WELWYN HATFIELD COUNCIL – DEVELOPMENT CONTROL
DELEGATED REPORT

APPLICATION No:	<u>N6/2007/272/FP</u>
------------------------	------------------------------

The application proposes the installation of external perforated shutters to the shop frontage. The shutters would be finished in white. No details of the housing have been submitted with the application.

Customer	Morgan Hussey <i>LITCHFIELD JEWELLERS</i>
Date	7.2.07
Drawn By	Colin Hughes
Title	Plan View Of Shutter Layout

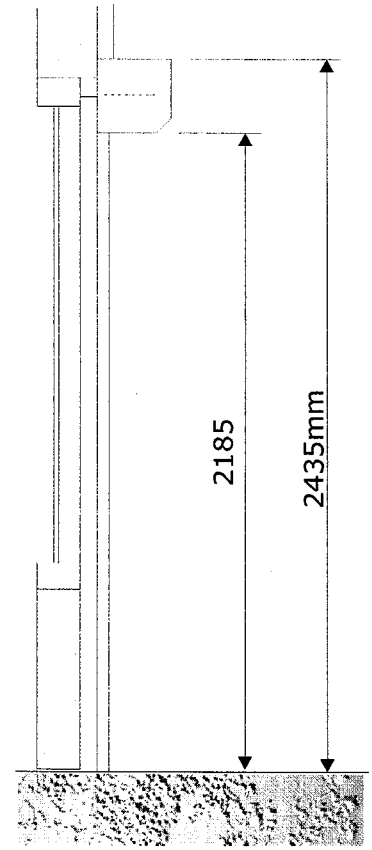
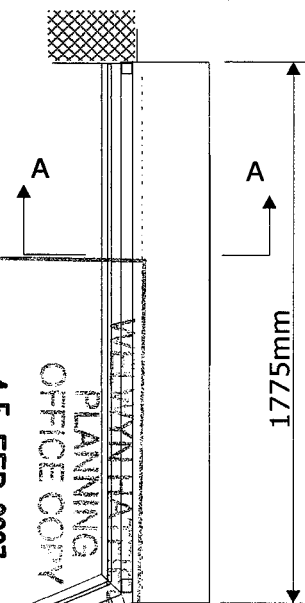
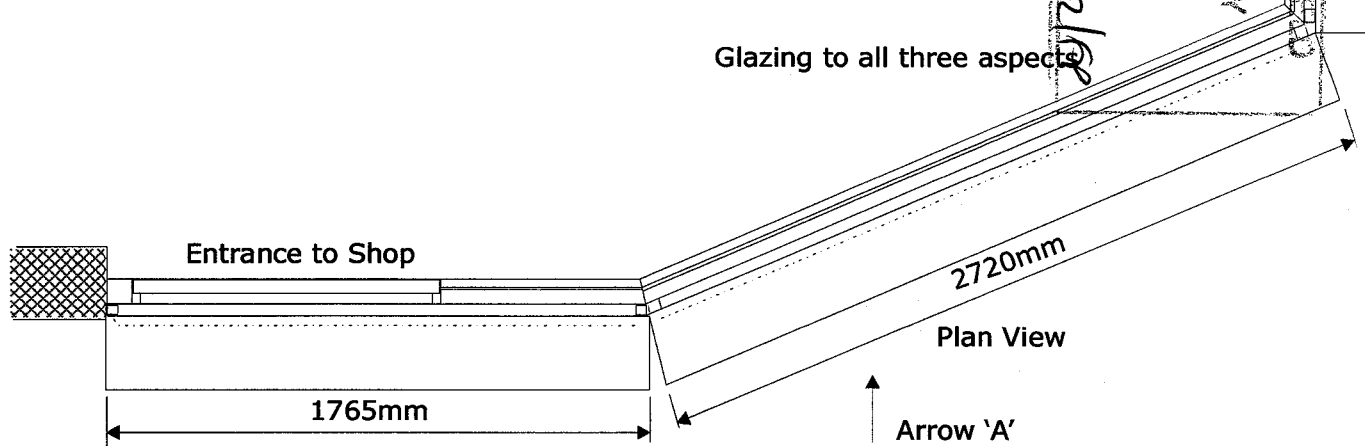
With regards to the housing for the shutter, it is important that this forms an integral part of the design of the shop front and does not appear as a 'bolted-on' addition. Whilst it would not hide any architectural features, the proposal should respect the shop front fascia and not stand proud of it, and as such should be fully incorporated into the fascia and the runners incorporated into the pilasters. Details of the housing have not been incorporated with the submission and further details in relation to the housing details would therefore be required in addition to a larger scaled plan. The existing fascia above the sign is unsightly and officers consider that a suitable housing can be achieved via condition.

3) Prior to the commencement of the development hereby approved, a plan at a scale of not less than 1:25 showing the design of the perforated lath shutter and the design of the housing, shall be submitted to and approved in writing by the local planning authority. Subsequently the proposal shall be implemented in accordance with the approved details unless otherwise agreed in writing by the local planning authority.
